Lead Local Flood Authority
Post Point CHN 215
Hertfordshire County Council
County Hall, Pegs Lane
HERTFORD SG13 8DN
www.hertfordshire.gov.uk

Date 14 July 2023

RE: 6/2023/1354/COND – 71 Station Road, Cuffley, EN6 4HG

Based on the information that has been provided in support of application 6/2023/1345/COND, the LLFA **objects to this application as there is not enough technical information to support the Discharge of Condition 4 (Drainage).**

WAVIN CELLULAR STORAGE SYSTEM DETAIL
SCALE: 1:25

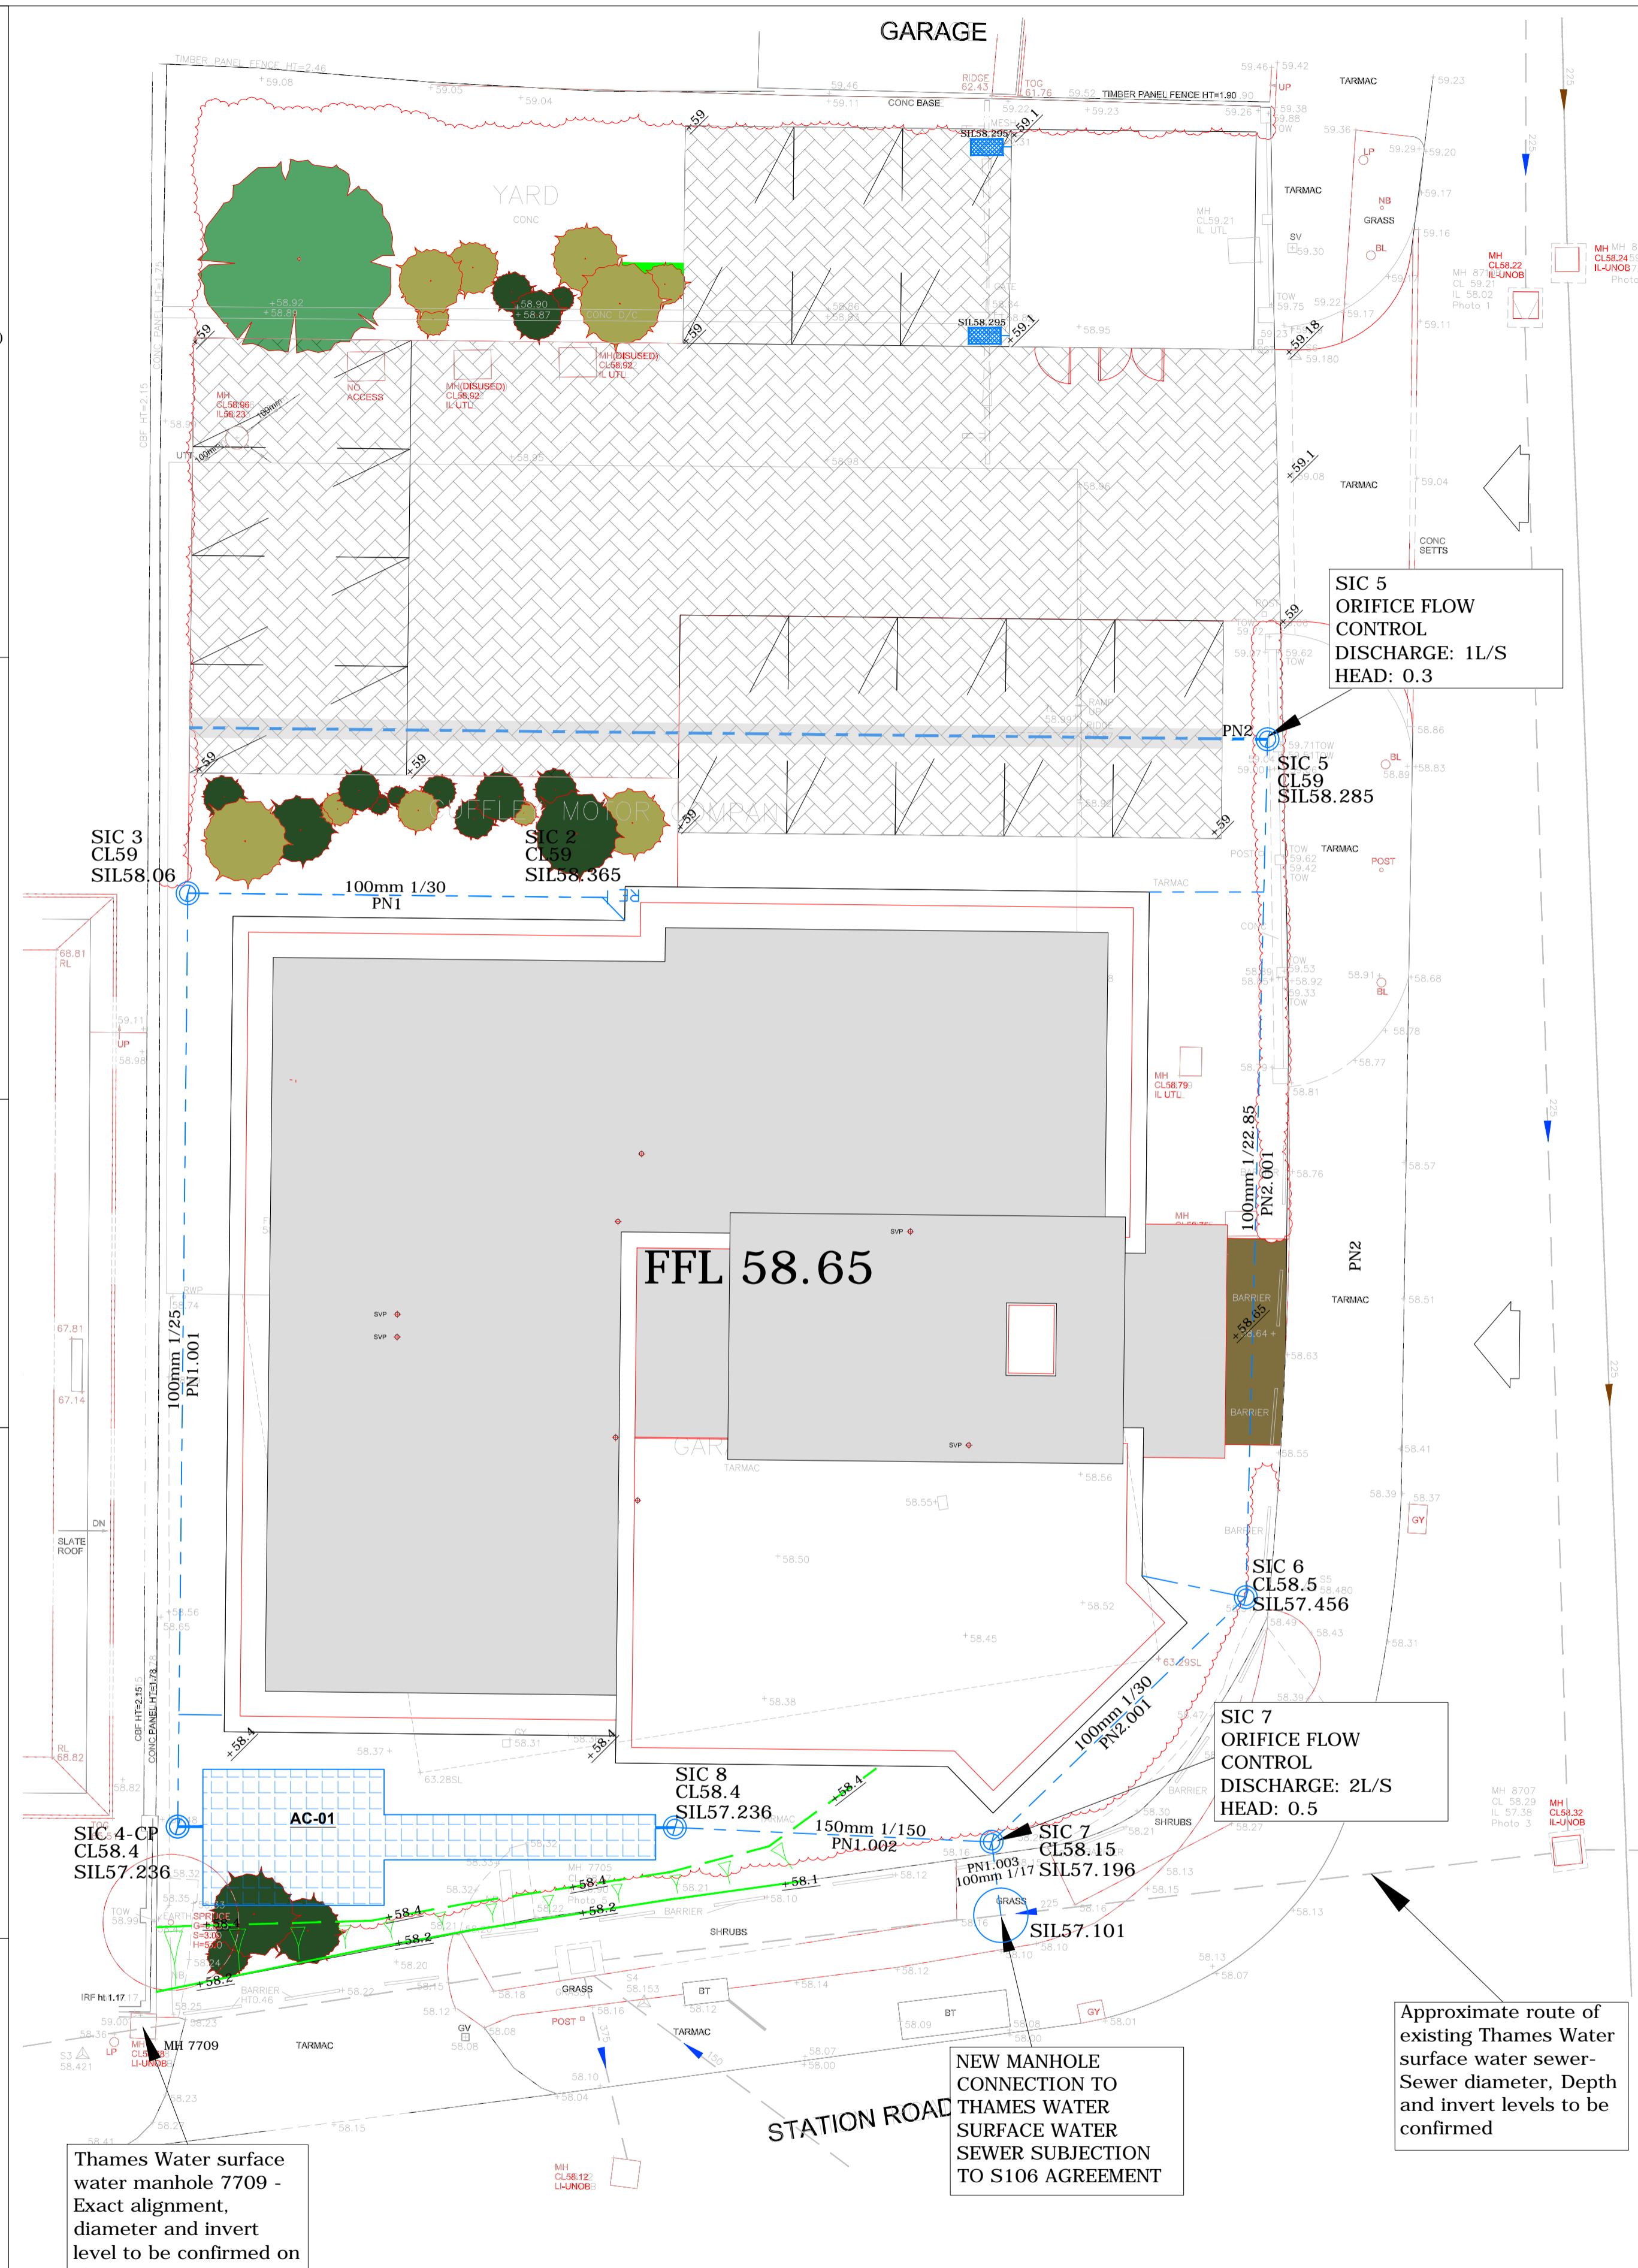
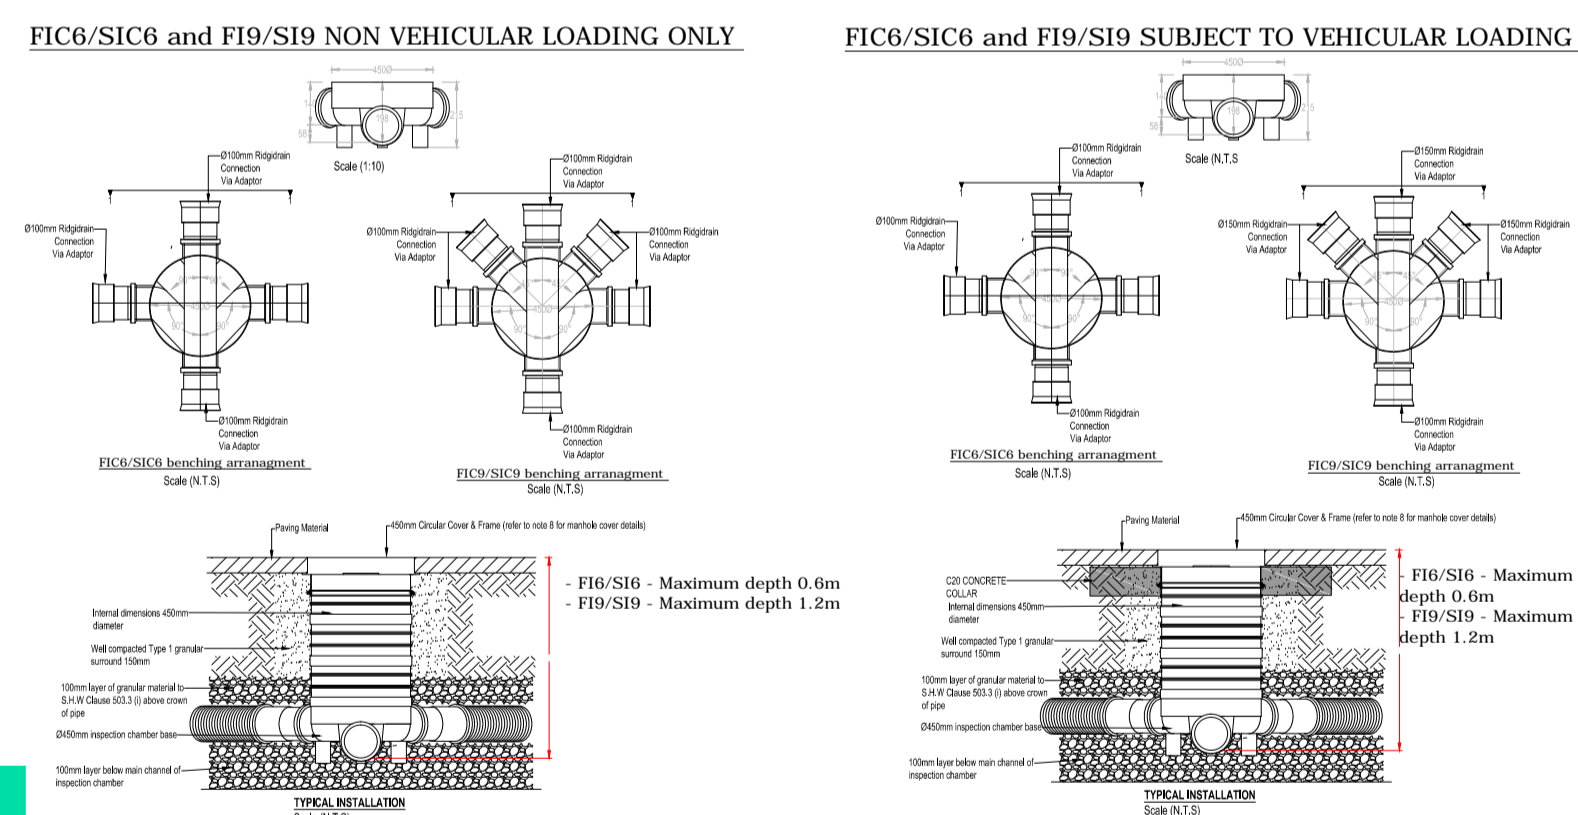
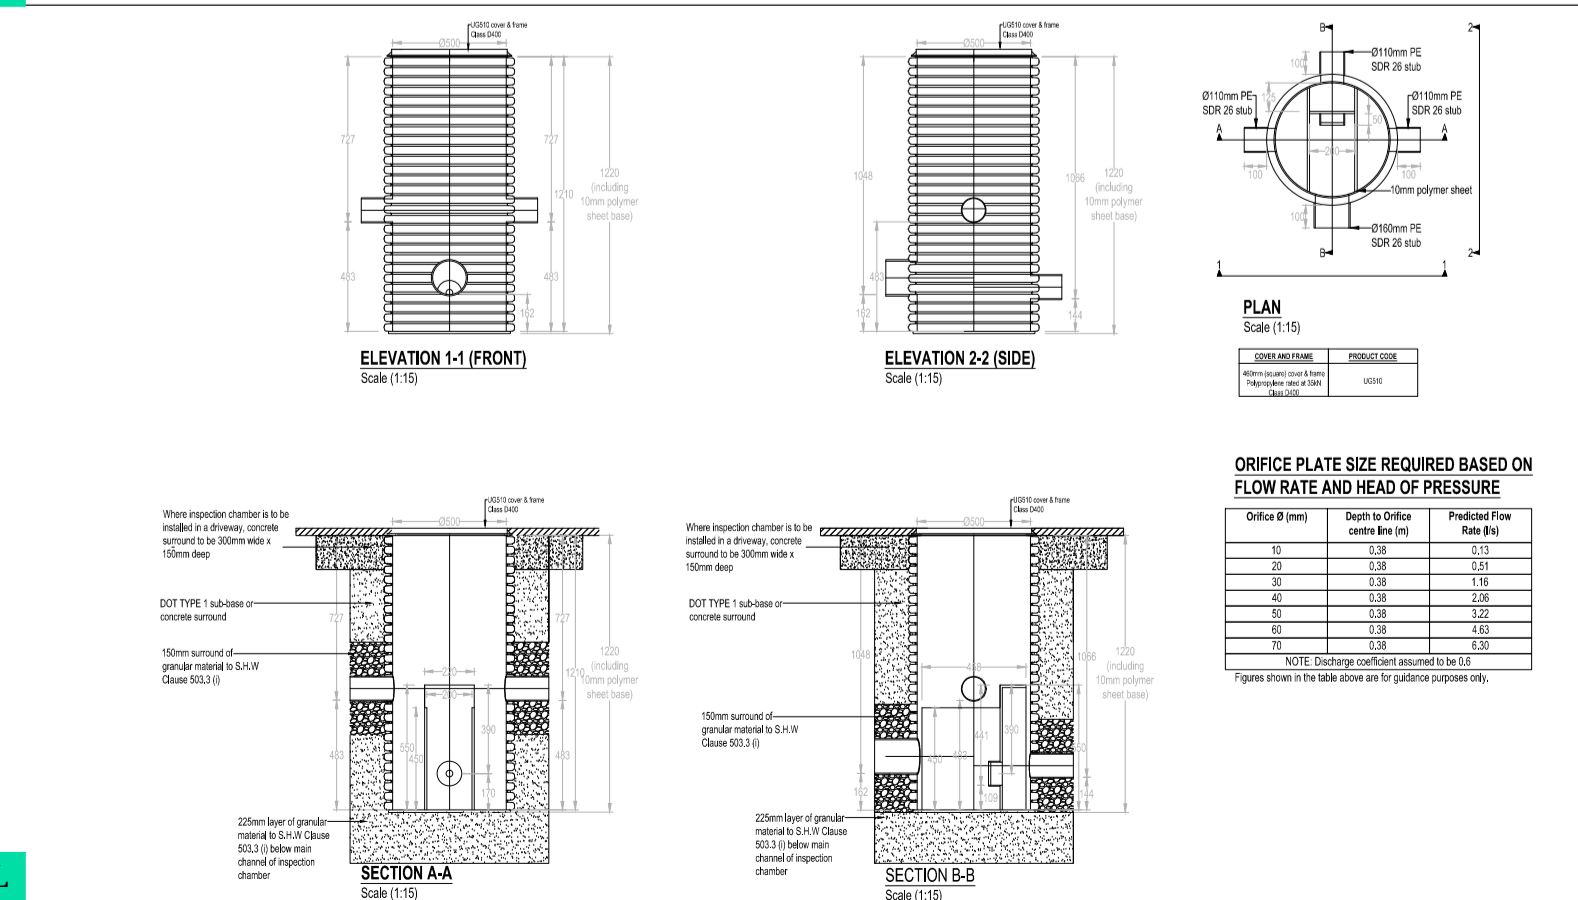
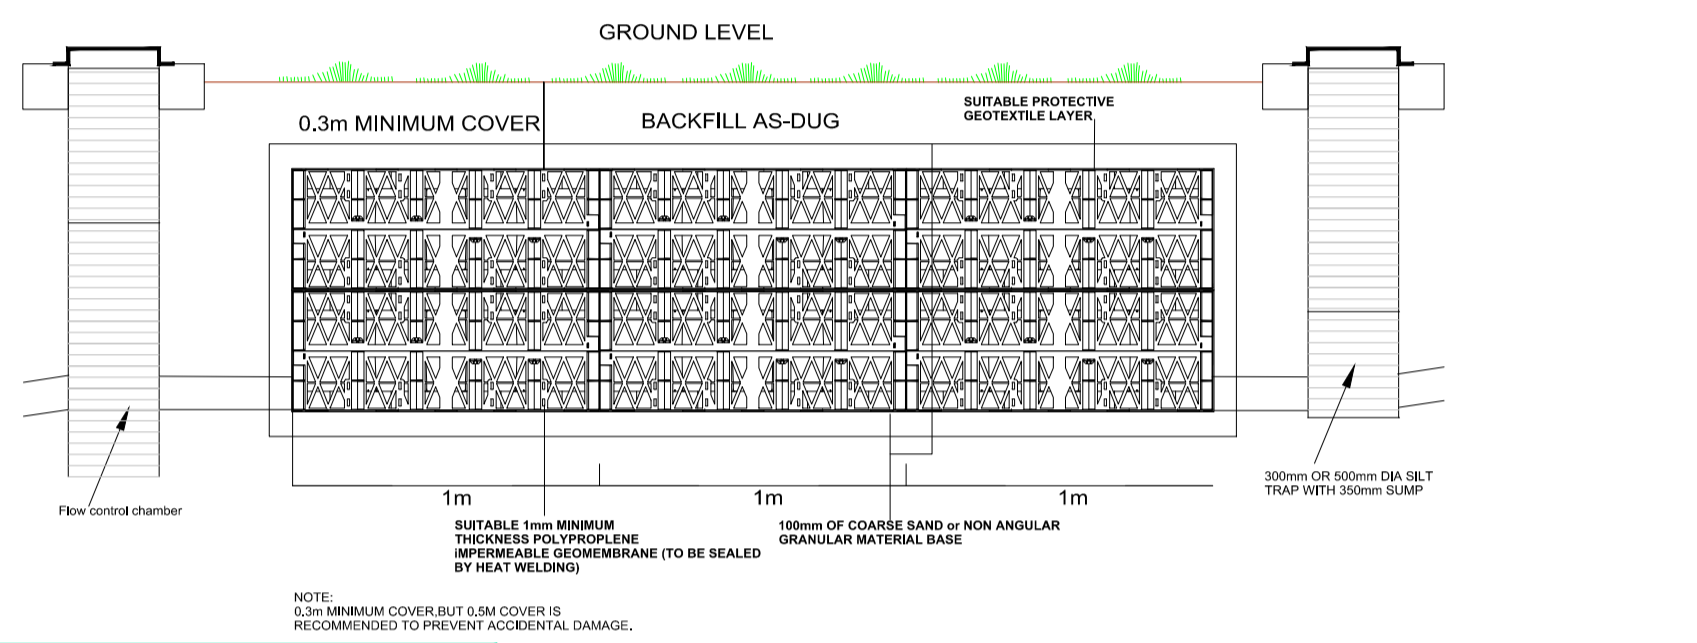
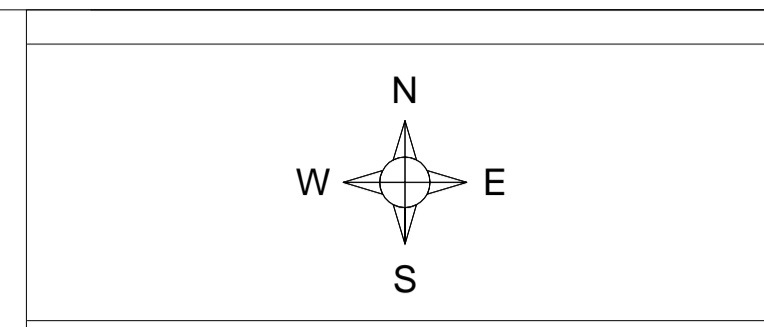
- c. While the LLFA appreciates the applicant's submission of the engineering drawing displaying the proposed SuDS features and some of the details, these are incomplete. The LLFA requires further information to be included on the drawing including the sizes, volumes, depths, and a complete set of levels of all features to enable the LLFA to review the hydraulic modelling calculations. The LLFA also requires further information on the grey area below the block pavers.

- 5. The LLFA notes that within the current calculations, there is a Flood Risk for pipe number 1.003 within the 1% plus 40% climate change allowance AEP design event. The LLFA requires the applicant to review their design to remove this risk.

- g. The applicant has not provided any evidence relating to silt traps for protection of any residual tanked elements. If these have been included, the applicant must provide further information on these features. If they have not been included, the LLFA requires justification as to their exclusion.
